Harnett County Government Complex
307 Cornelius Harnett Boulevard
Lillington, NC 27546

"DA"
CONF # 36580

Re: Status of Improvement Permit Application #05-5-12614

Revised

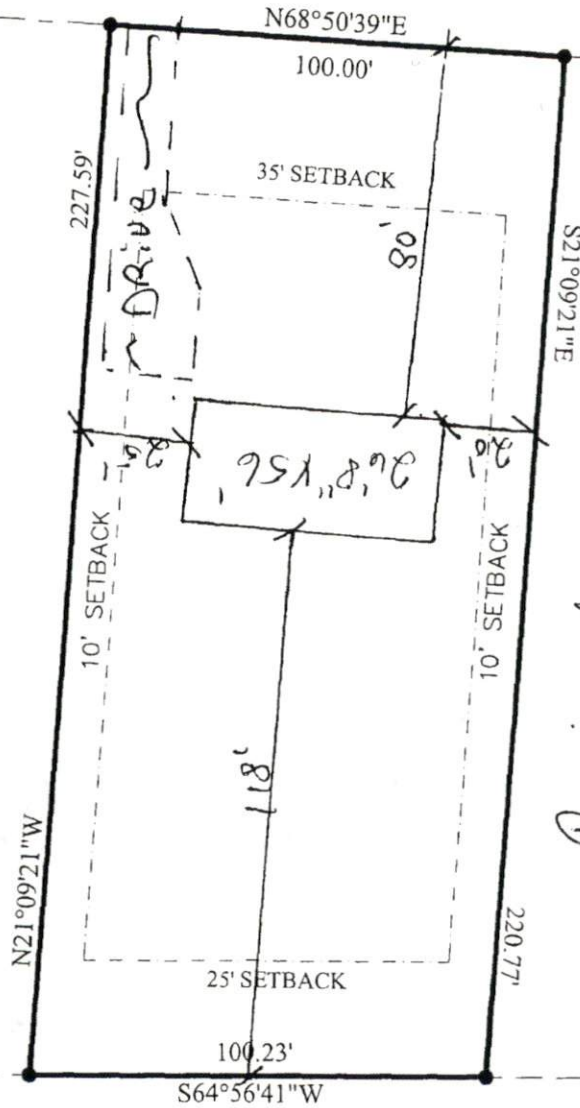
- 1. Property lines/corners not marked or labeled
- 2. House corners not marked or labeled
- 3. Directions not clear to property
- 4. Property needs brush or vegetation removed
- 5. Backhoe pits required
- 6. Other **Move house back as shown – Please make changes as required and submit to Central Permitting. You will need to reconfirm through the IVR system**
